August 3, 2023

**Re: Maverik- Albuquerque**  
**2121 Yale Blvd. SE**  
**Traffic Circulation Layout**  
Engineer's/Architect's Stamp XX-XX-XX (M15-D021D)

Based upon the information provided in your submittal received 07-26-23, the above referenced plan cannot be approved for Building Permit until the following comments are addressed:

ALBUQUERQUE, NEW MEXICO

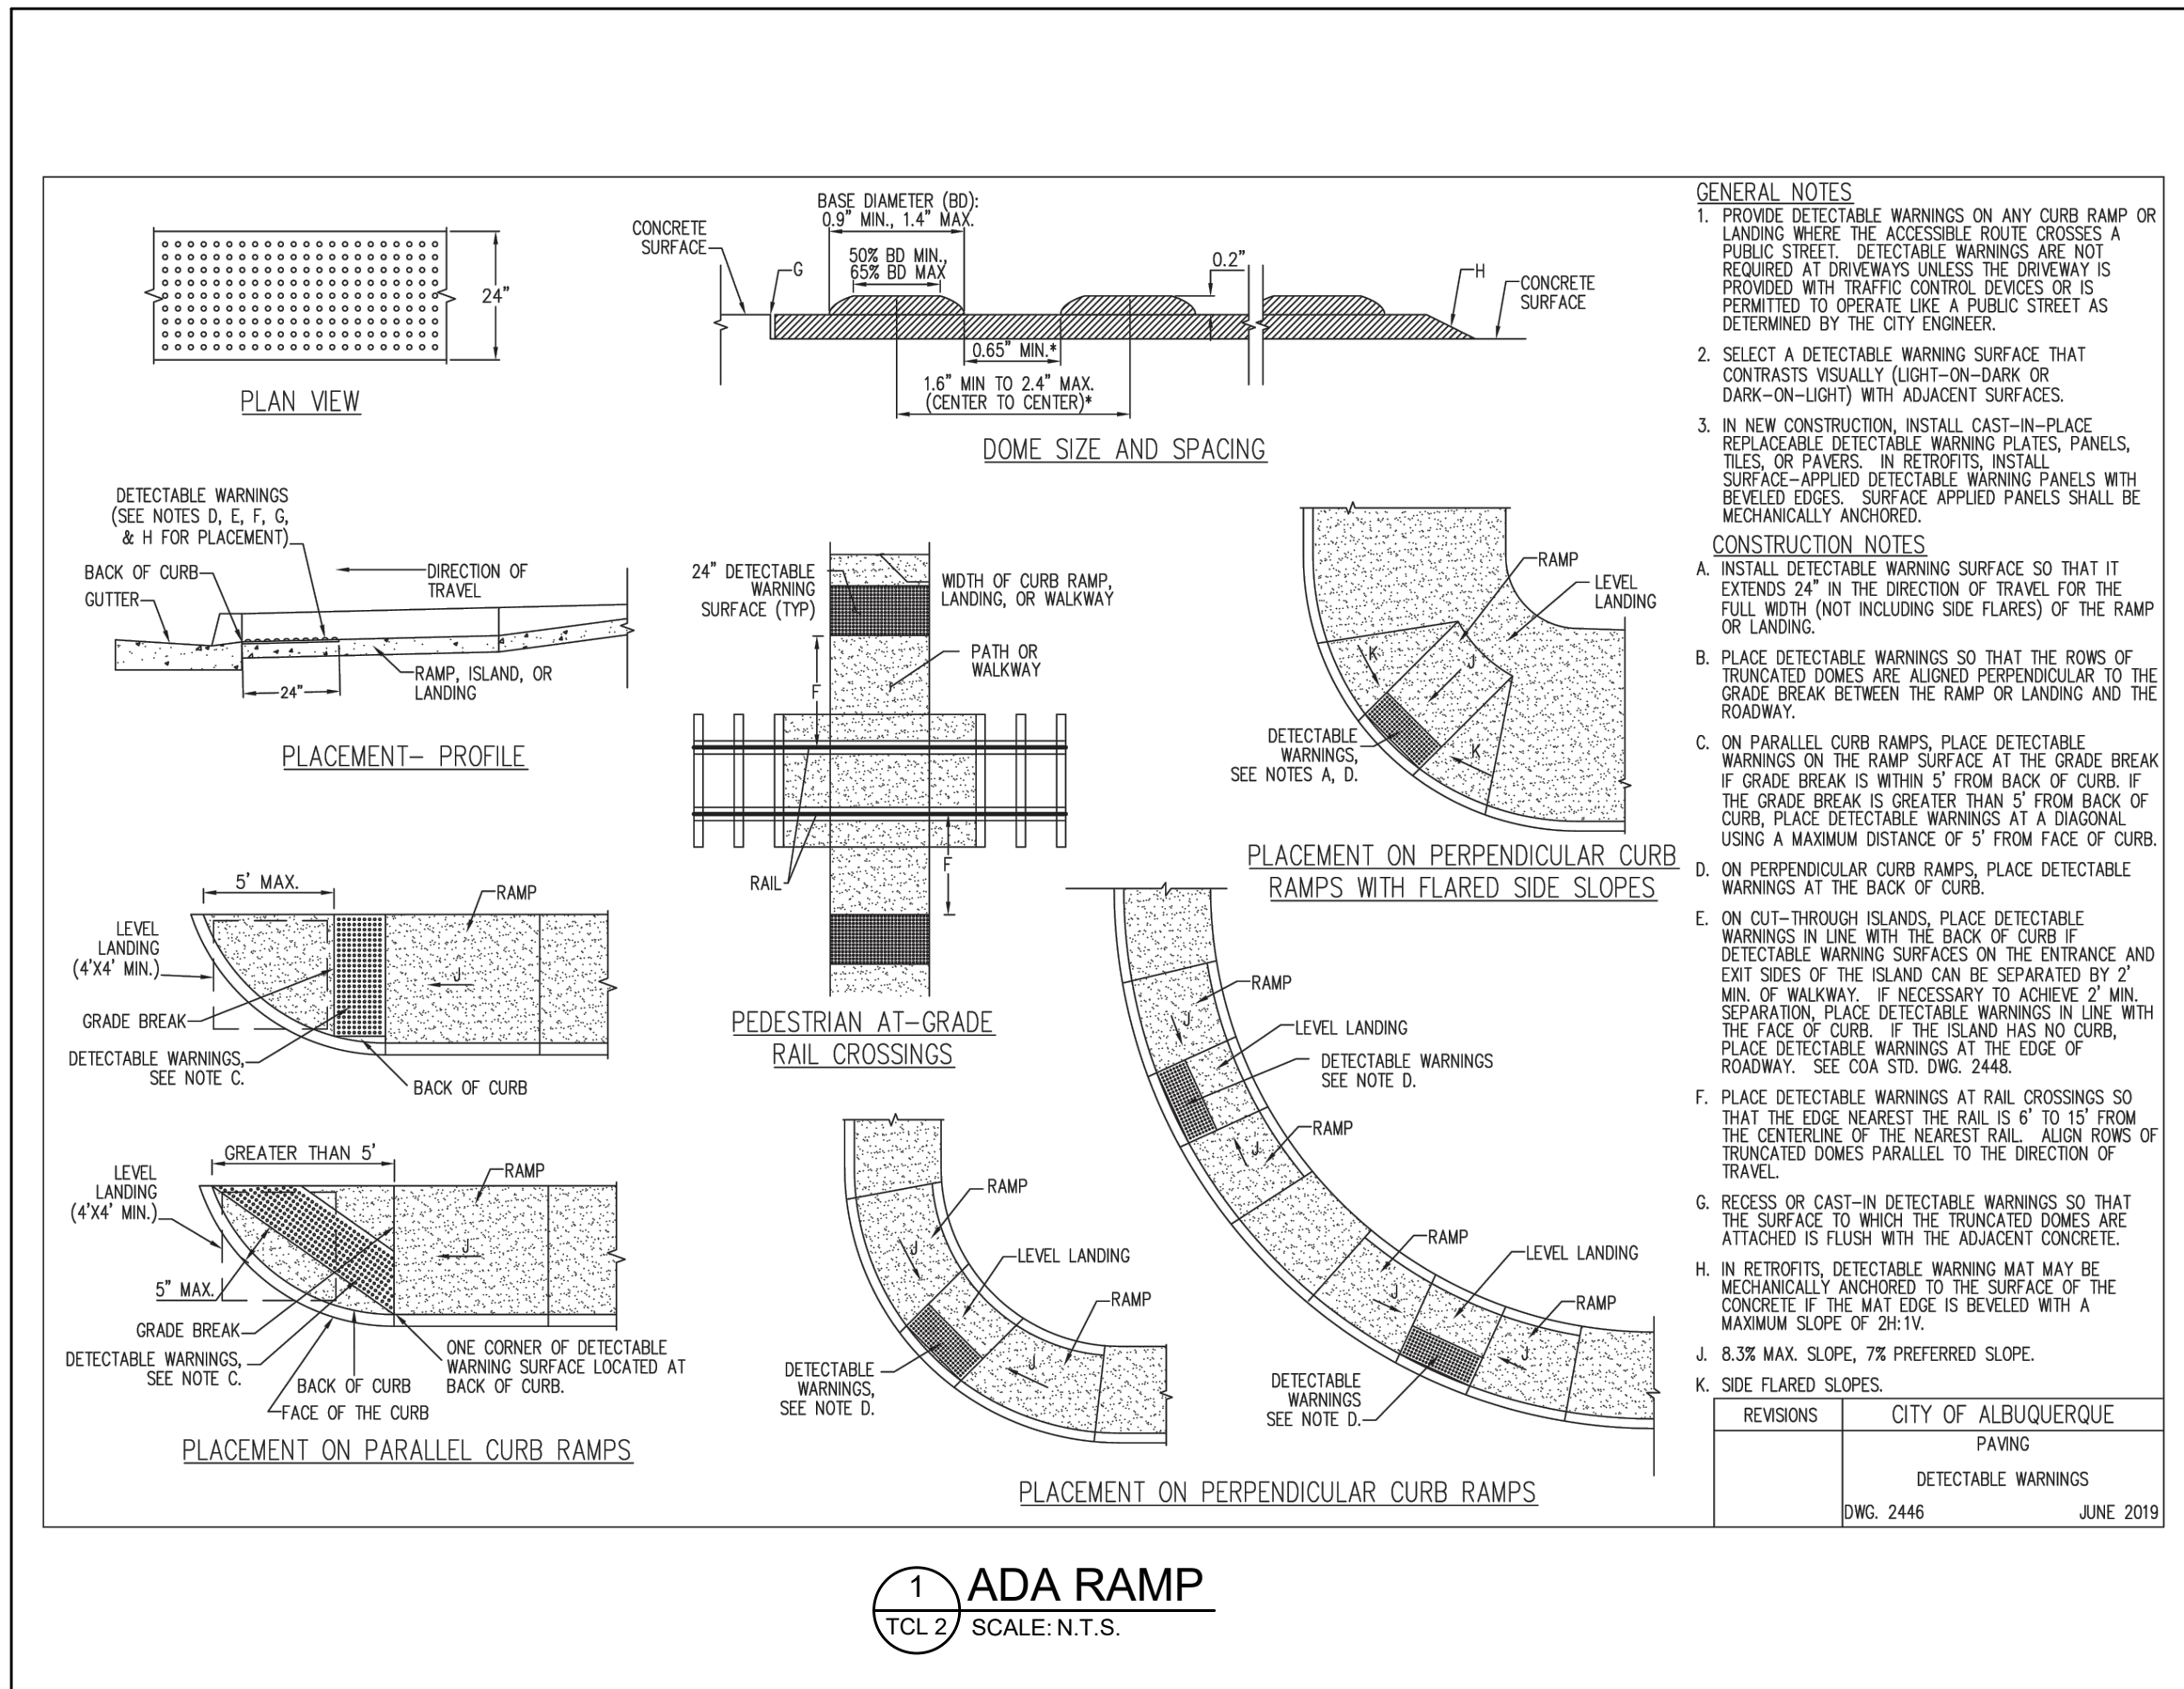
1. List the number of Motorcycle parking spaces required by the IDO.
2. The traffic circulation layout must be stamped, signed, and dated by an engineer or architect licensed in the state of New Mexico.

3. Identify all existing access easements and rights of way width dimensions.
4. Identify the right of way width, medians, curb cuts, and street widths on Gibson Blvd., Yale Blvd. and Miles Rd.

5. A minimum 5 ft. Wide sidewalk and 5 ft. wide buffer is required to be developed from property line to property line along Miles Rd. please show dimensions and details on the site plan, and reference COA std dwg 2430.

6. Please clarify: are you going to develop a sidewalk and buffer along Gibson Blvd. and Yale Blvd.? If so, please provide details and reference COA std dwg.

7. Site access off Miles: Show on the site plan the site access details and radii.
8. The ADA accessible parking sign must have the required language per 66-7-352.4C NMSA 1978 **"Violators Are Subject to a Fine and/or Towing."** Please call out detail and location of signs.

9. ADA curb ramps must be updated to current standards and have truncated domes installed.
10. Motorcycle parking spaces shall be designated by its own conspicuously posted upright sign, either free-standing or wall mounted per the zoning code.

11. The pavement marking "MC" should be shown in the opposite direction for motorcycles entering the parking space.
12. All bicycle racks shall be designed according to the following guidelines:

- 16. Per the IDO, a 6 ft. wide ADA accessible pedestrian pathway is required from the public sidewalk to the building entrances. Please clearly show this pathway and provide details.

- 17. Per DPM, a 6 ft. wide ADA accessible pedestrian pathway is required from the ADA parking stall access aisles to the building entrances. Please clearly show this pathway and provide details.

- 18. ADA accessible pedestrian pathway should not be placed behind parking space or adjacent to a vehicular way. Vehicle and pedestrian/wheel chair conflicts should be avoided as much as possible.

- 19. Refuse vehicle maneuvering shall be contained on-site. The refuse vehicle shall not back into the public right of way.; provide a copy of refuse approval.

- 23. Work within the public right of way requires a work order with DRC approved plans.
  - 24. Please add a note on the plan stating "All improvements located in the Right of Way must be included on the work order."

- 25. Unused curb cuts must be replaced with sidewalk and curb & gutter. A build note must be provided referring to the appropriate City Standard drawing.
